Planning Application No: 3/2023/0591

Proposal: Proposed single-storey extension to rear, pitched roof over front porch and side garage and demolition of rear conservatory.

Location: 9 Hereford Drive Clitheroe BB7 1JP

The LHA have reviewed the new information received ALH drawing number 06C titled "Proposed Site Plan" and are aware that the driveway will be extended to provide 2 car parking spaces for the existing and proposed 4 bed dwelling.

PROPOSED SITE PLAN

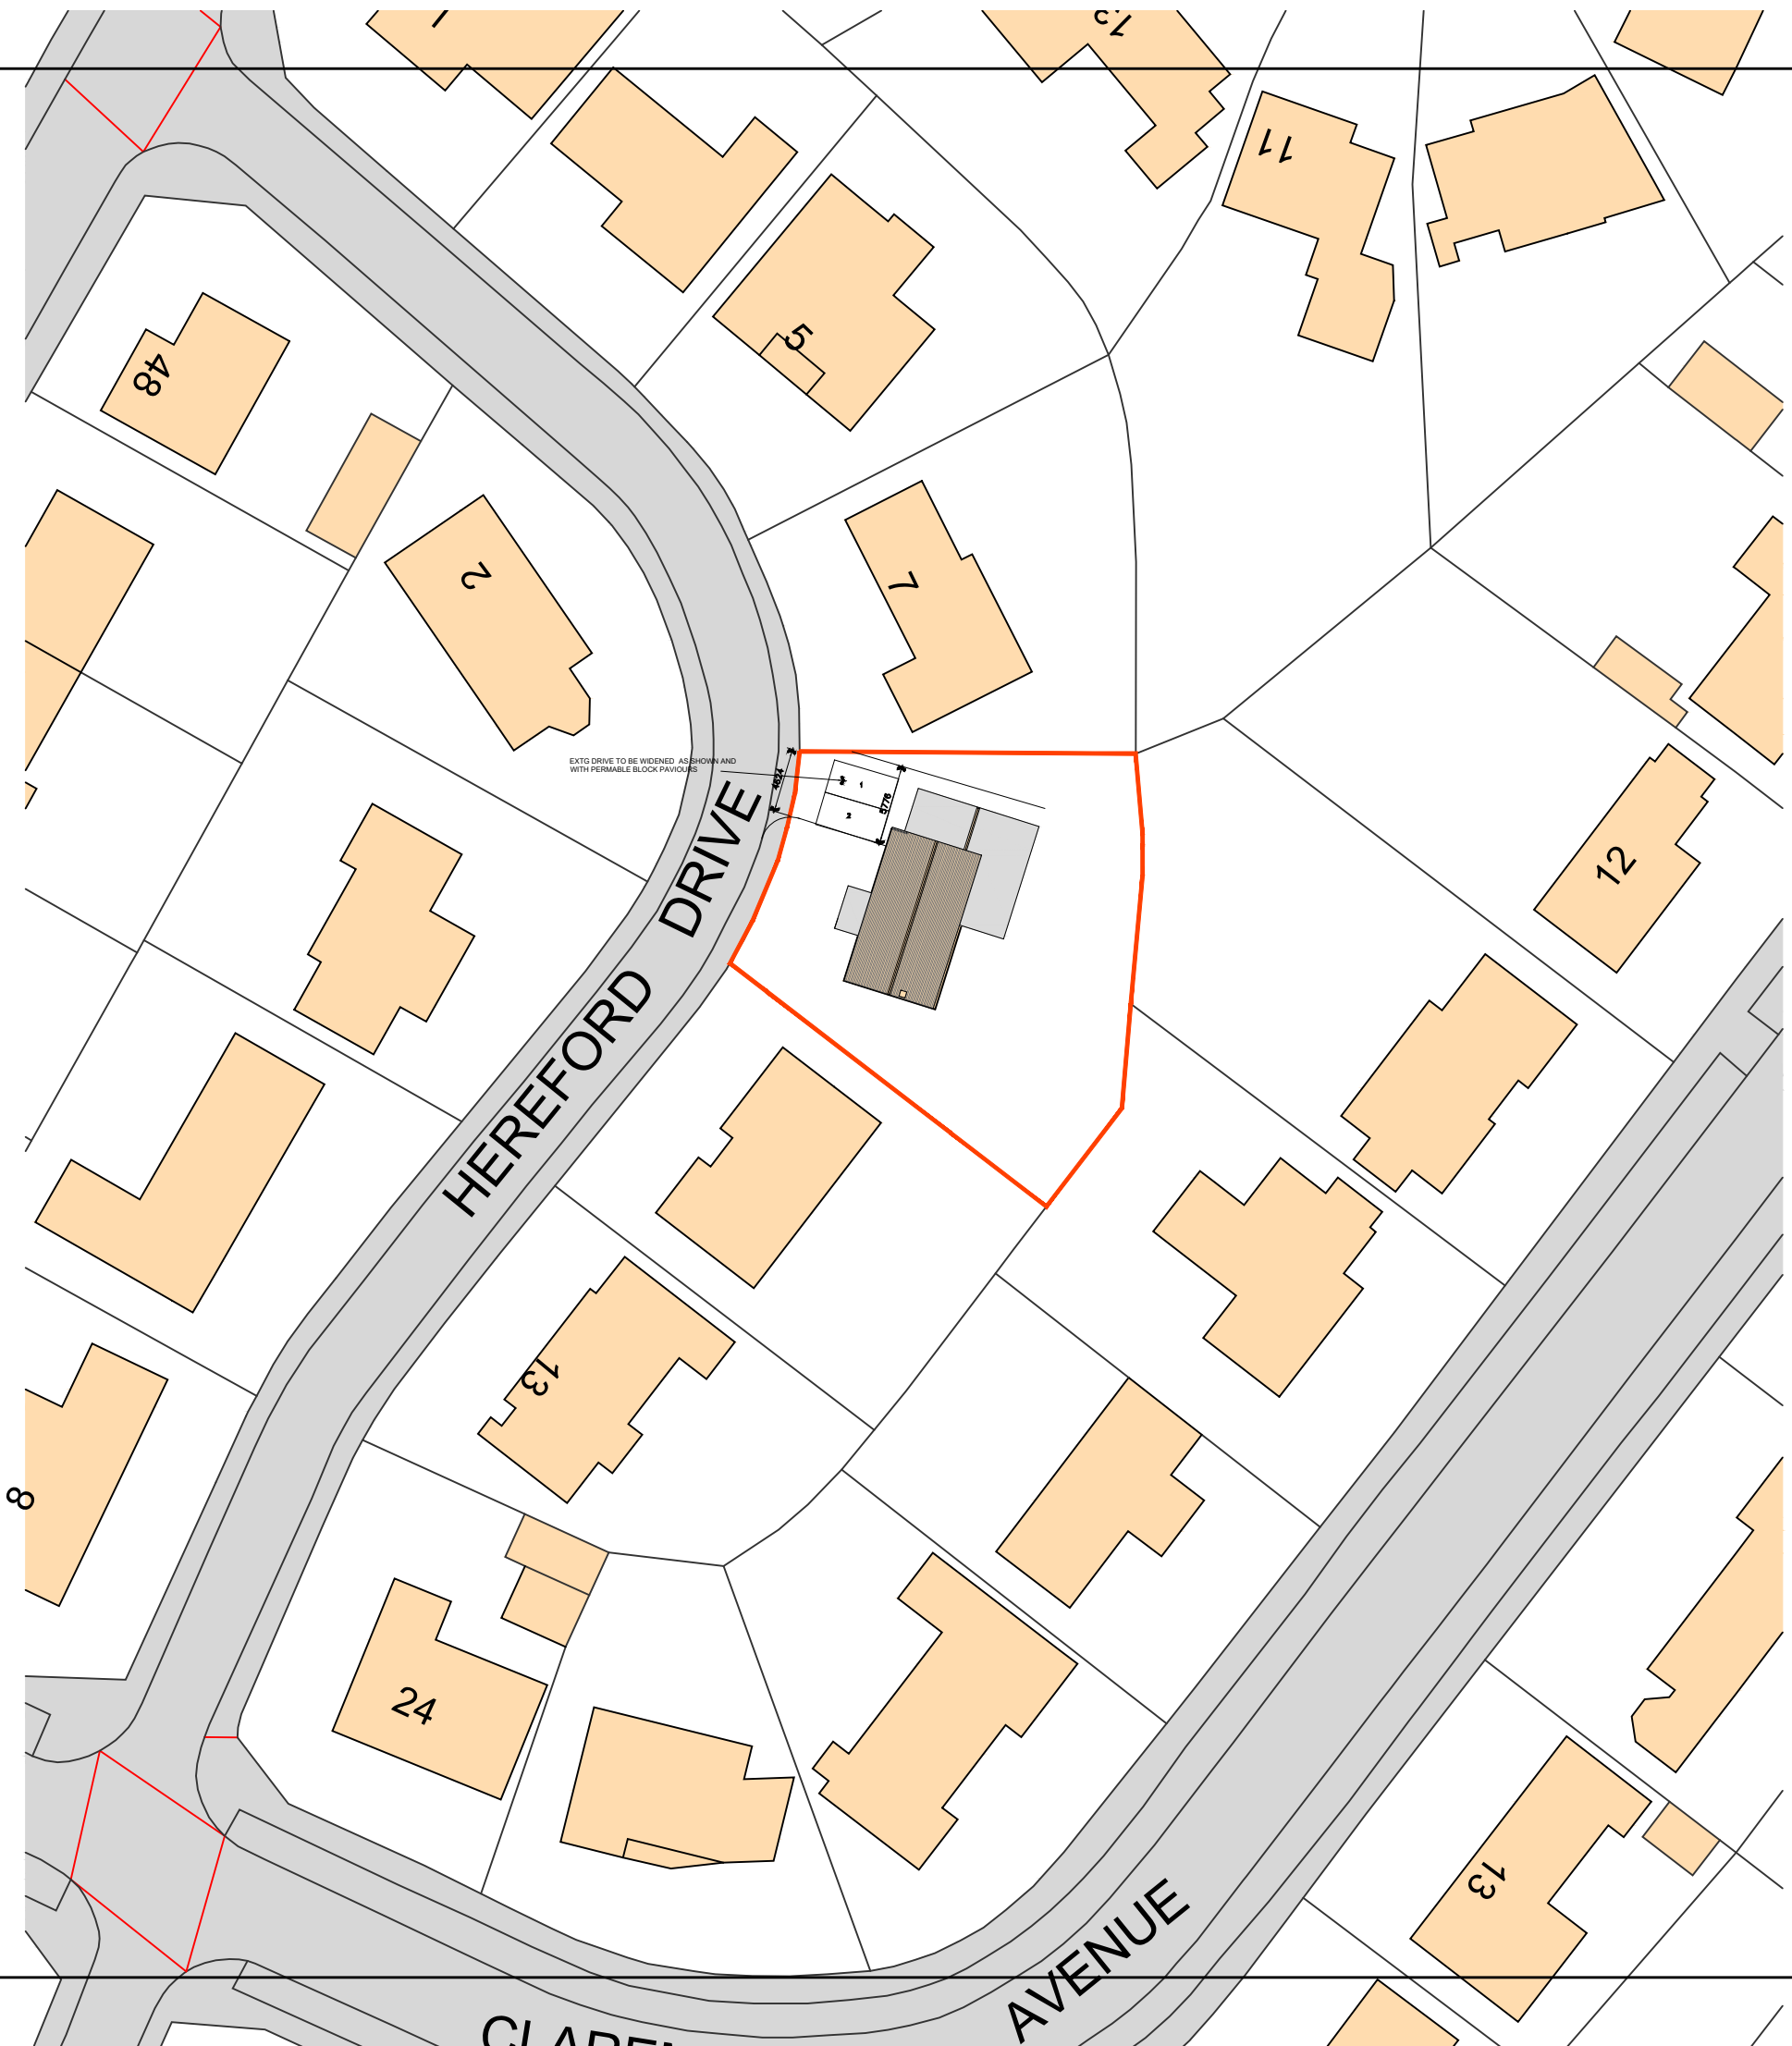
The LHA welcome the extension of the driveway, which will include the widening of the existing dropped kerbs at the site, with the parking arrangements now being seen as better than the existing arrangements. The LHA now have no objection to the proposal but would advise the Applicant to widen the driveway to provide 3 car parking spaces for the site to fully comply with the LHAs parking guidance as defined within the Joint Lancashire Structure Plan.

The LHA following the proposal require the Applicant to apply for a dropped crossing application. Please see the informative below for more information.

- The parking areas must be constructed of a bound porous material and created before first occupation up until the lifetime of the dwelling existing in its proposed state. Reason: To ensure that satisfactory parking is provided before the dwelling hereby permitted becomes operative.
